**Sirius Building (SSD-10384)
Public Exhibition**

Thank you for your correspondence via the Major Projects Portal on 17 November 2020, requesting Transport for NSW (TfNSW) to review and comment on the above.

BASEMENT B2b-B2a

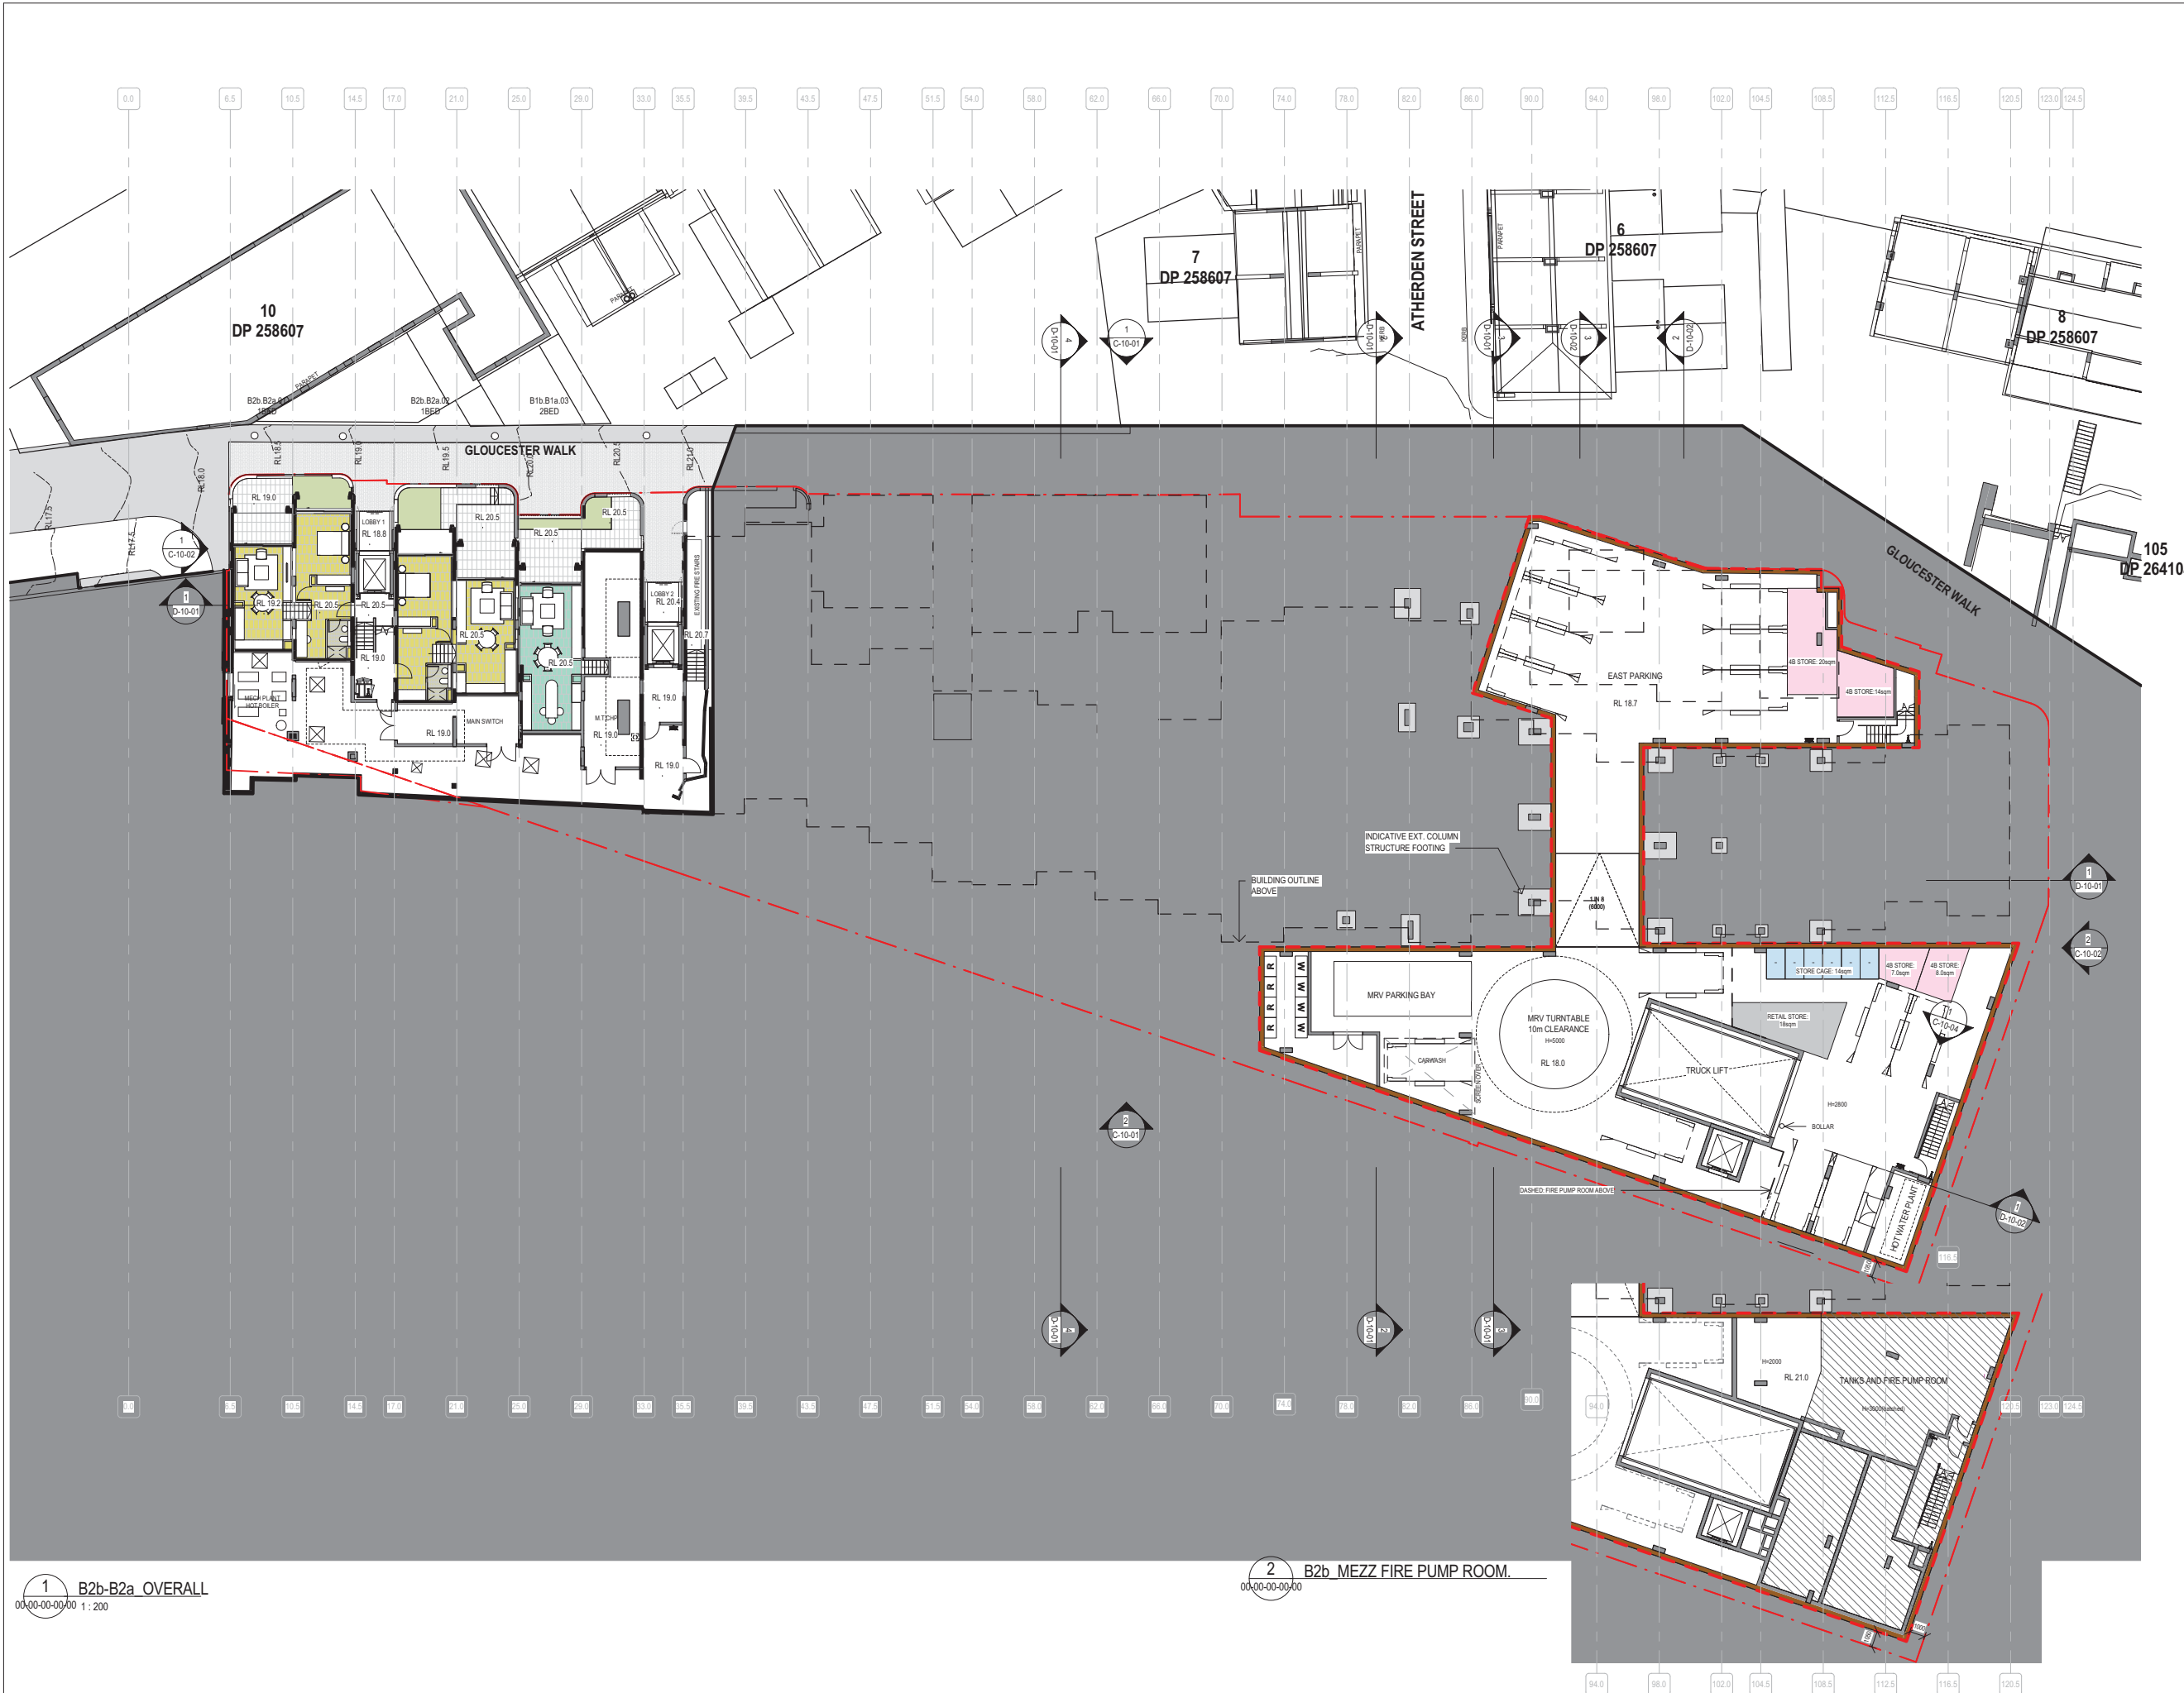
Section 5.5 of the Traffic Impact Assessment prepared to support the development application states that a loading bay is provided within Basement 2b and is accessed via a truck lift from the Cumberland Street frontage.

No information is provided to demonstrate that the proposed loading dock space will be adequate to accommodate the freight and servicing demand for the development.

It is requested that:

- The applicant provides details in relation to the demand and management of service bays for the residential, retail and commercial components of the development as part of the response to submissions; and
- The applicant be conditioned to prepare a Loading and Servicing Management Plan in consultation with TfNSW, prior to the issue of any Construction Certificate.
